CONSERVATION & DESIGN ADVICE

WHBC Offices, The Campus, WGC

N6/2013/1938/MA

Proposed 3 storey rear (east elevation) infill extension & single storey rear extension to provide additional office accommodation, Council Chamber & associated works: Amended proposals

Title Proposed Materials

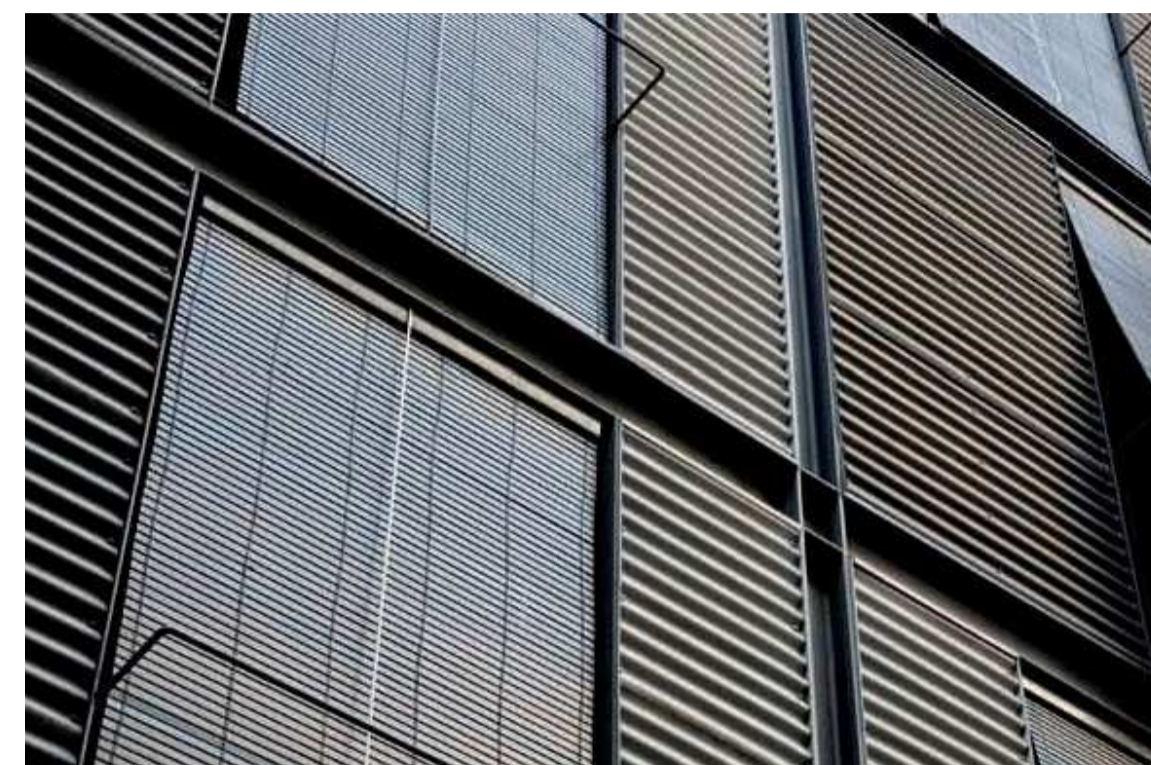
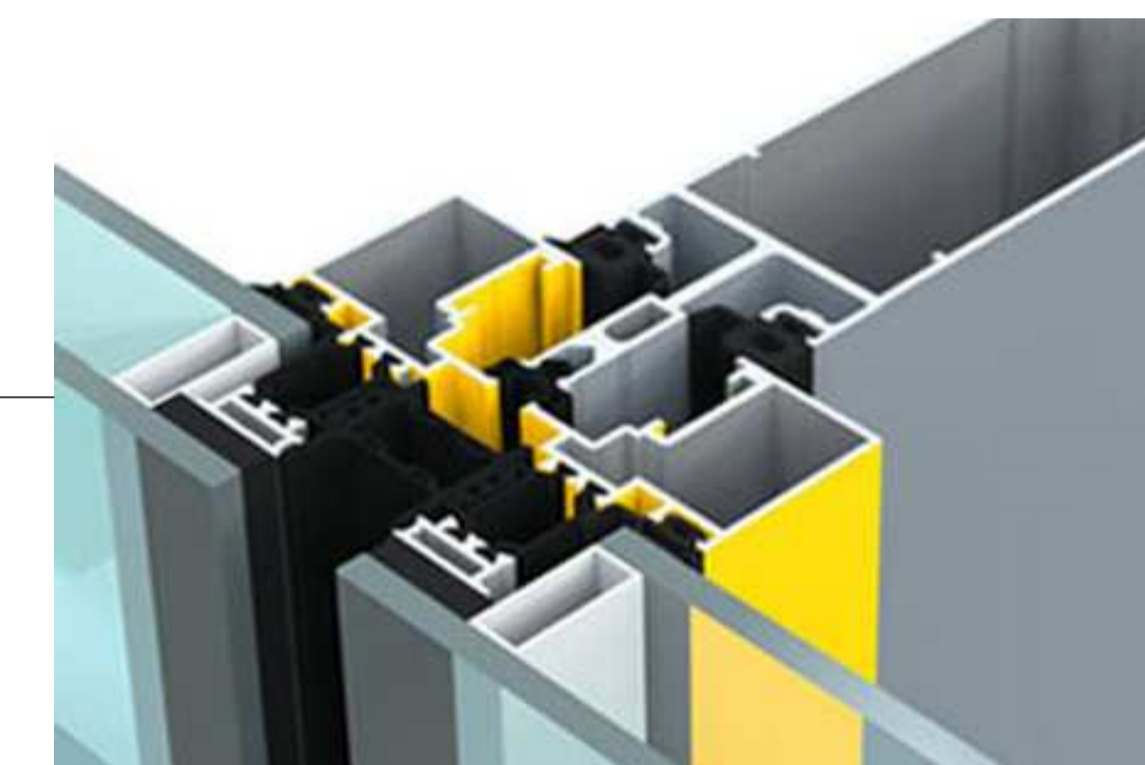
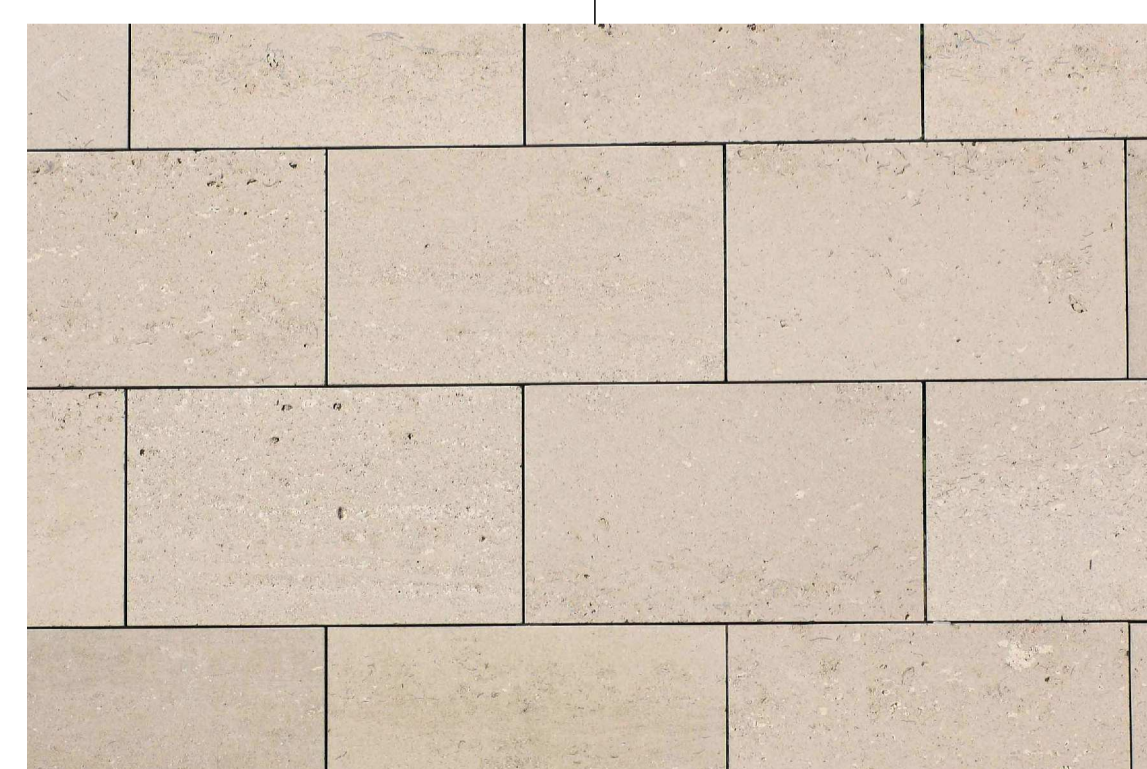
The scale of the proposed stone edged framing to the structural glass screen wall (now, in this amended proposal, vertical rather than inclined & with a slimmer, more refined, moulded cross-section) is a bold feature of the extension, which projects through the eaves line of the existing office building- but is, importantly, lower than the ridge of that roof. The side infill walls are in brick with windows of classical proportions. The proposed entrance is emphasised as the focal point of the east elevation, which helps to reduce the perception of an out of scale glazed screen. That screen is sub-divided into vertical glass panels, cut by horizontals of the floor bands, which helps, to some extent, in referring to the proportions of the earlier building.

The materials of the proposed extension are high quality structural glass with stainless steel connections & structural support & a stone surround, set in front of the plane of the glazed screen to form a distinct shadow line, adding somewhat to the richness of this proposed new façade of the extension.

The façade of the proposed east elevation extension is certainly a bold statement, expressing the difference of this part of the building, as a clear contrast to the original neo-Georgian building style. The amendments to the framing of the glazed screen has, it is considered, reduced the assertiveness of the appearance of the earlier proposed extension, to some extent, & increased the refinement of the architectural detailing. The height of the framing does not exceed the ridge of the roof.

On balance, with close attention to the selection of materials of clear high quality & to detail (such as lighting & external views looking into the new extension), the proposed extension would be a functional & striking contemporary addition, which could provide a further layer of interest to this comparatively tucked away part of the conservation area, to the rear of the 1935 offices.
